27 April 2012

Our ref: 2162189B LT_5675REVA/DC/kt

Request to Modify Major Project 06_0028: HCB Waste Repackaging Plant - Modification 6 — Response to submissions

Figure 3.1 Approved and proposed HCB storage envelope at Depot 11/51

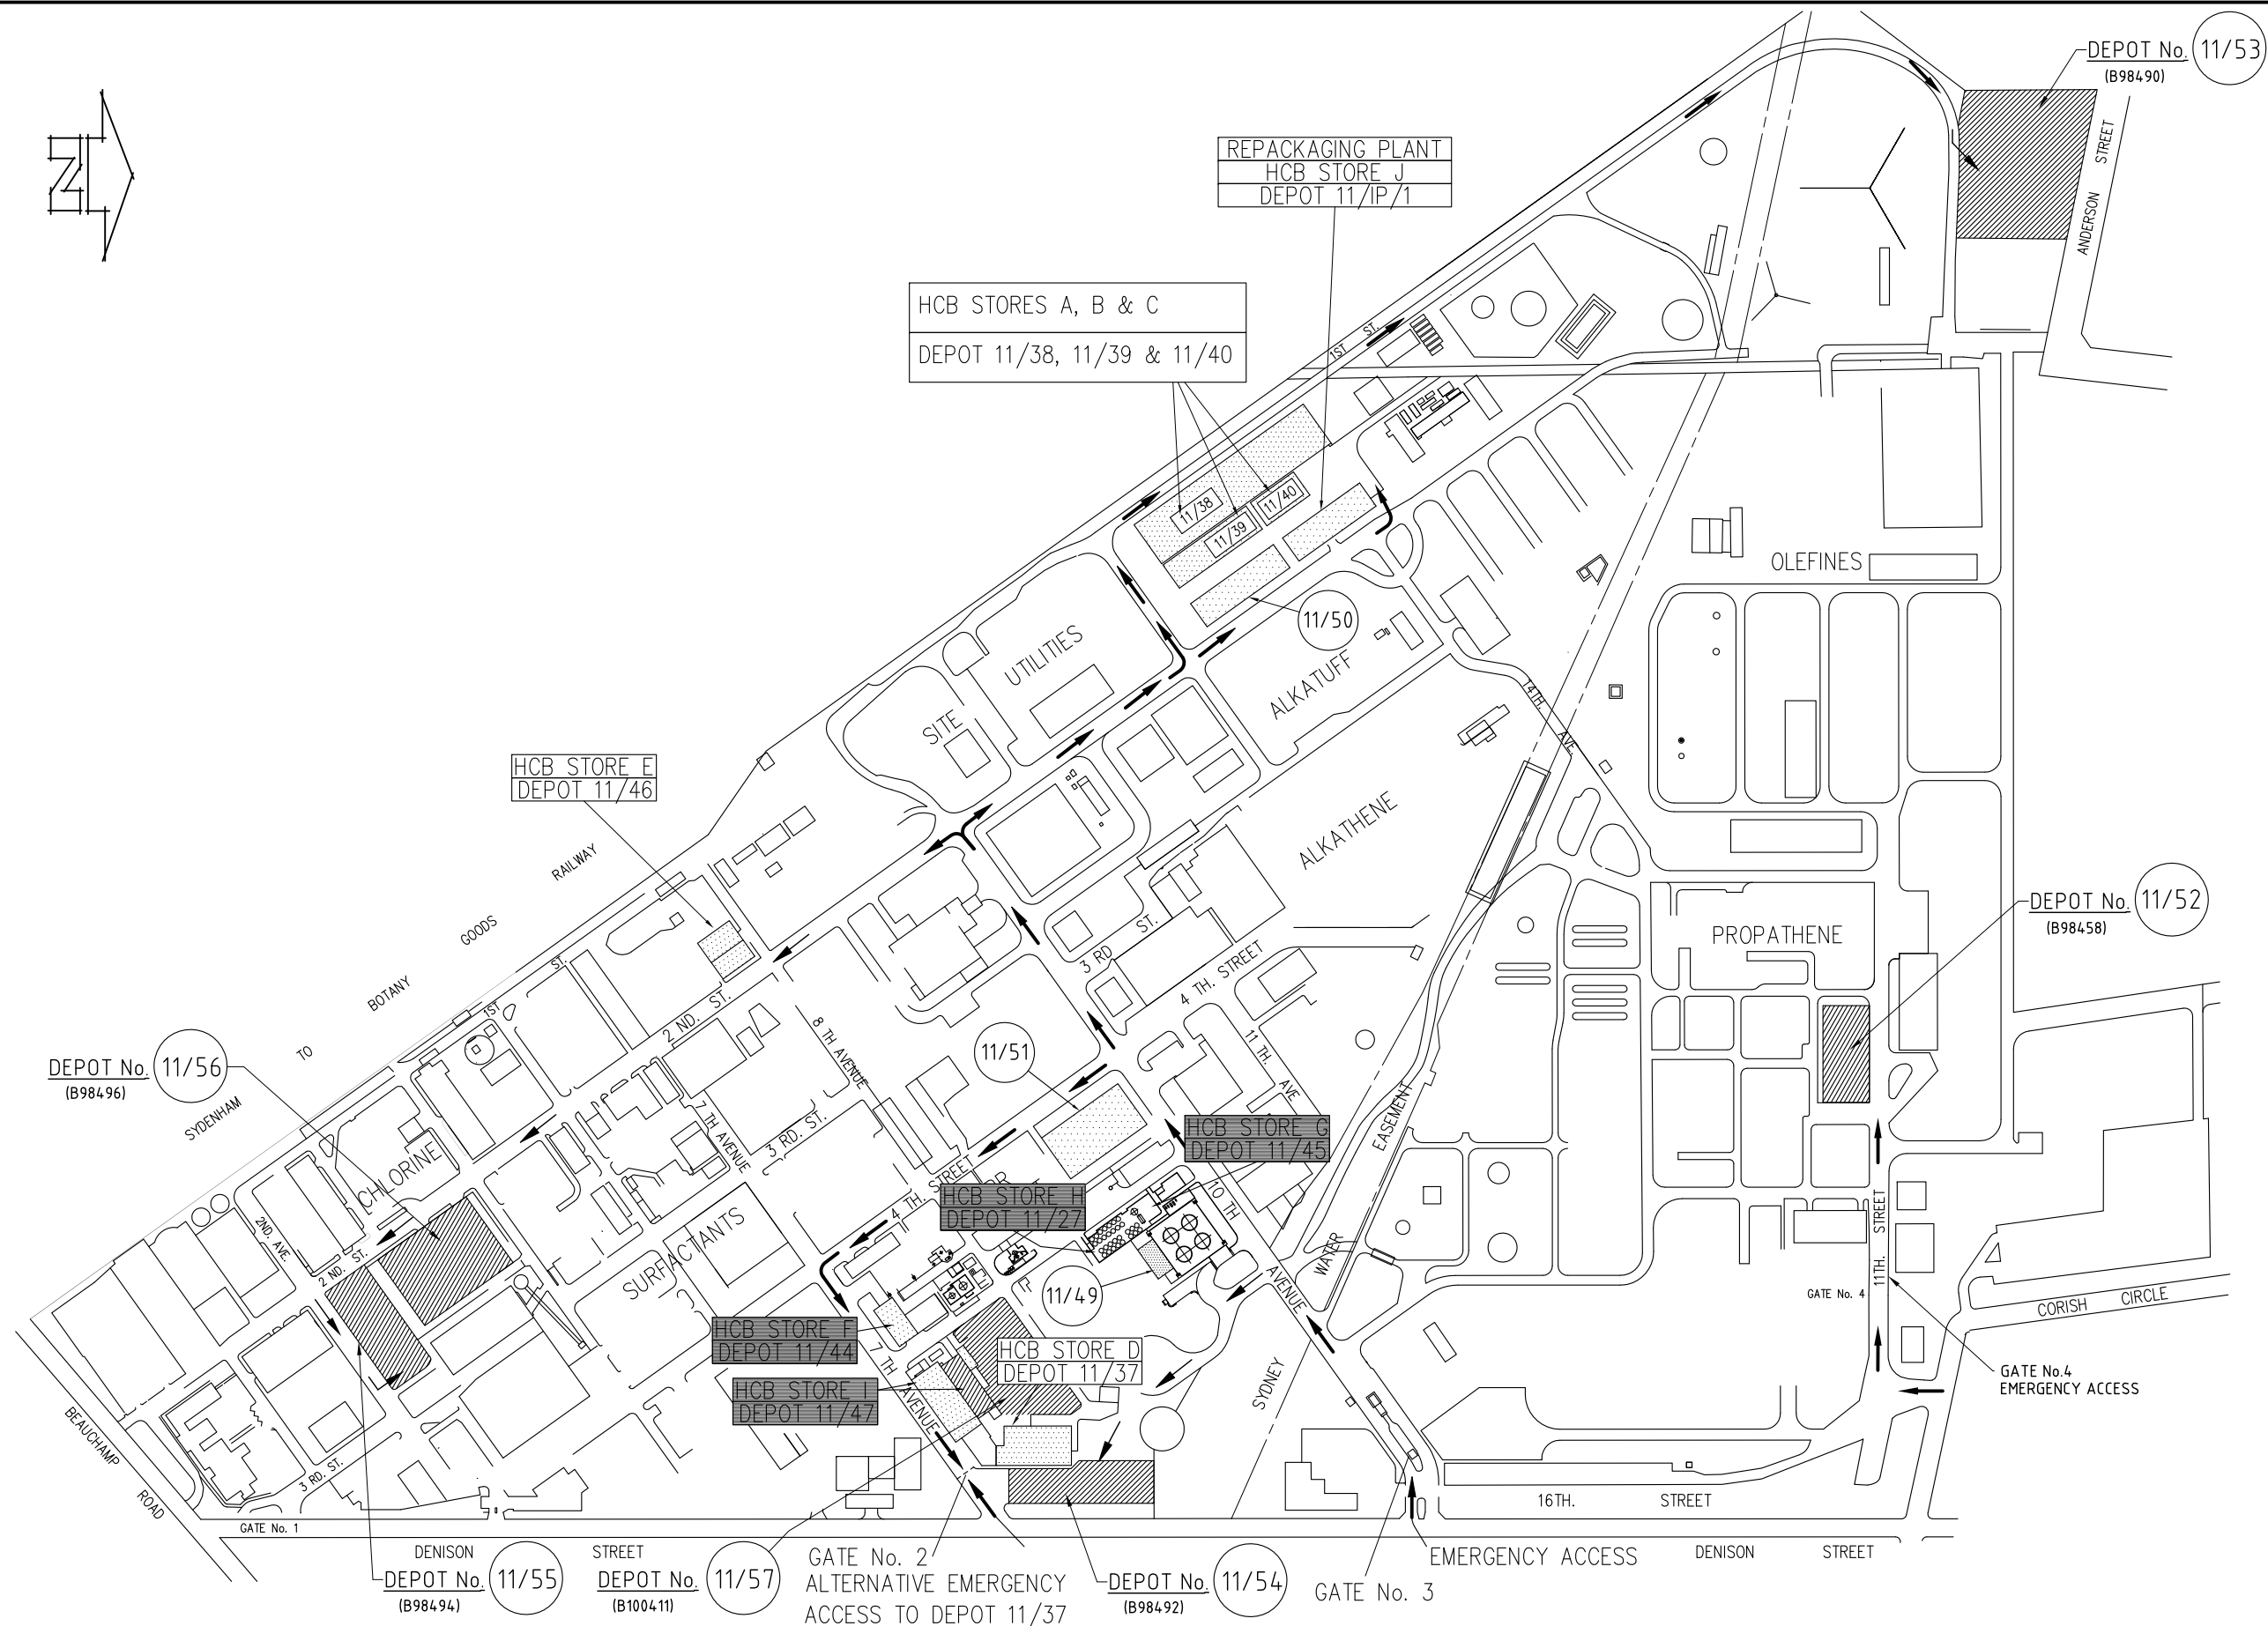
What is the existing footprint of depot 11/51?

Workcover lists the depot as being roofed, was there ever a roof over depot 11/51?

Depot 11/51 was created in 2006, and was approved as part of Modification 3 of Major Project 06_0028. The existing footprint of Depot 11/51 is shown in Figure 3.1 of the Report and is described in Appendix B of the Supporting Documentation for Modification 4 of Major Project 06_0028. Depot 11/51 does not and never has had a roof, but drums of HCB waste have been enclosed within shipping containers on site.

The Proposal entails installation of a roofed shed and annexe on an expanded Depot 11/51 footprint. It is proposed that Depot 11/51 would occupy the expanded footprint shown in Figure 3.1 of the Report.

Figure 3: Modified HCB waste storage locations

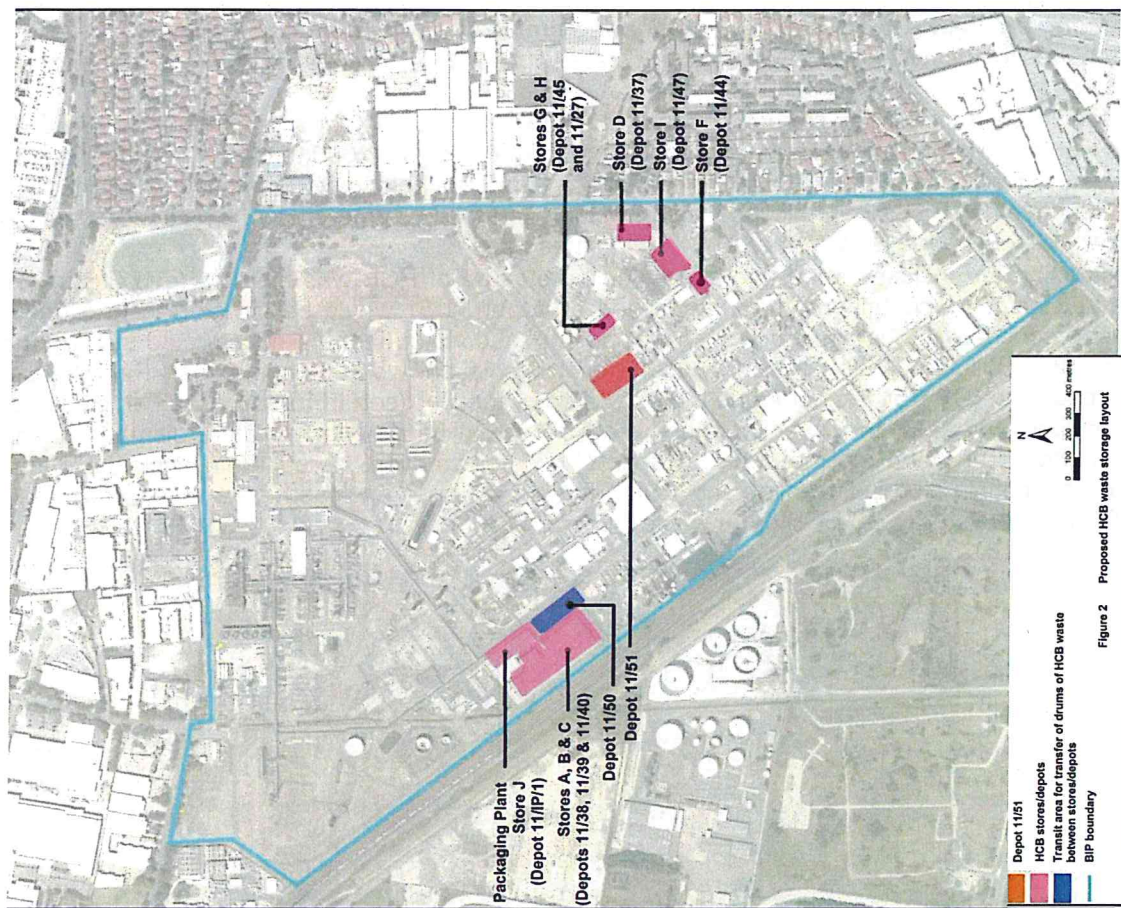
The assessment states that repackaged drums would be transferred from other approved sites. From which sites?

As identified in the Report, the relocated FSB shed and new annexe are intended to store repackaged HCB waste currently stored at Depot 11/51 and other approved depots and stores at the BIP. Drums of HCB waste are likely to be transferred to Depot 11/51 from Depots 11/52 and 11/54, and Stores A, B, C, D, and F. The sources of HCB waste for Depot 11/51 as modified are shown in Figure 1.

This process would involve lowering densities of HCB waste stored at Depot 11/54 and Stores D and F. As shown in Figure 1.1, these stores are amongst the cluster of stores/depots closest to residential land uses on Denison Street. The Proposal entails moving the waste to a central location in the BIP and removes a substantial volume of HCB waste from storage at these locations.
